STATE OF NORTH CAROLINA
DEPARTMENT OF TRANSPORTATION

Addendum No. 1

RE: Contract # C204123
WBS # 41582.3.1
FEDERAL-AID NO. STP-0211(021)
Brunswick County (R-5021)
NC-211 FROM SR-1500 (MIDWAY RD) TO NC-87

December 7, 2021 Letting

TIP NO. R-5021	SHEET NO. PMP-4A
APPROVED: <u>Andrew D. Klincksiek</u> <small>ESD78FB4598E48...</small>	
DATE: 10/28/2021	
SEAL 	
DOCUMENT NOT CONSIDERED FINAL UNLESS ALL SIGNATURES COMPLETED

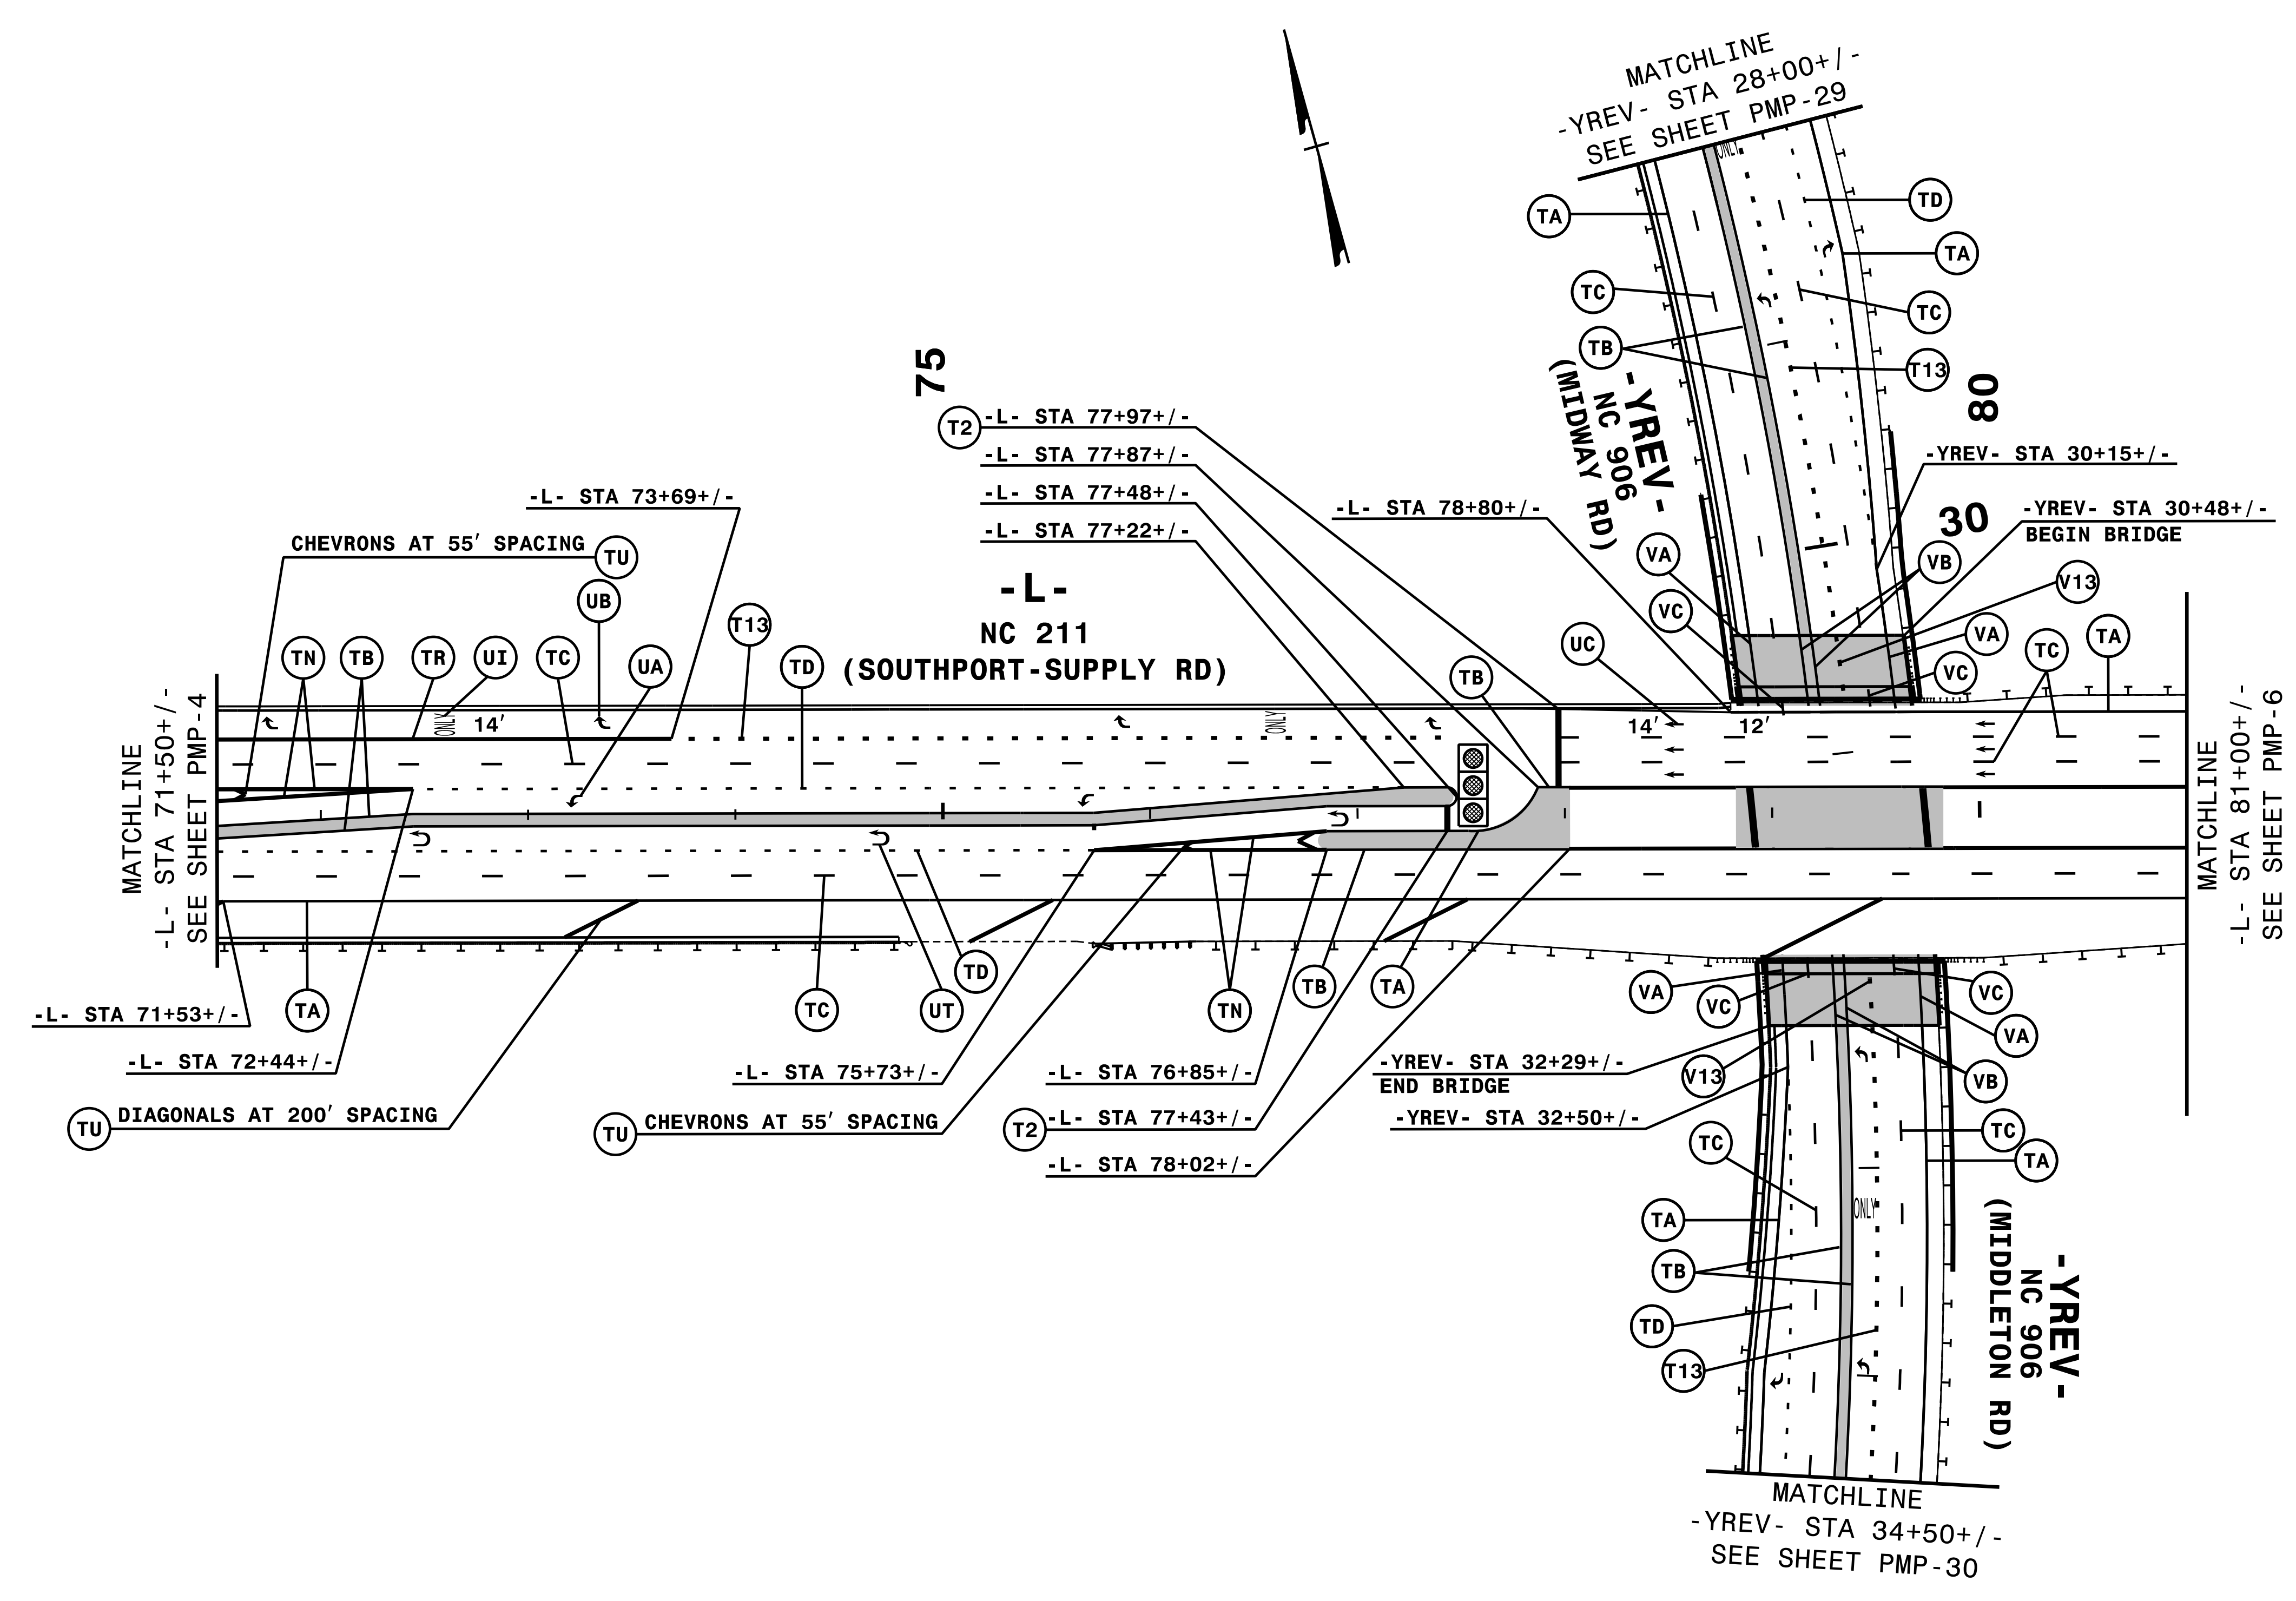
Sheet No.	Revision
PMP-1A	Updated to show additional marking symbols and line types to the Pavement Marking Schedule.
PMP-1B (NEW)	Added to show the addition of sheet PMP-4A on the key sheet.
PMP-4	Updated to show revised pavement markings along -L- and along the new Midway revision alignment -YAREV-.
PMP-4A (NEW)	Added to show the new roundabout along -YAREV-.
PMP-5	Updated to show revised pavement markings along -L-.
PMP-6	Updated to show revised pavement markings along -L-.
PMP-7	Updated to add markings for the westbound turn bay between stations 94+00 to 101+00.
PMP-19	Updated to add markings for the westbound turn bay into -Y9A-.
PMP-20	Updated to add markings for the westbound turn bay into -Y9A-.
PMP-30	Updated to show revised pavement markings along the new Midway revision alignment -YAREV-.
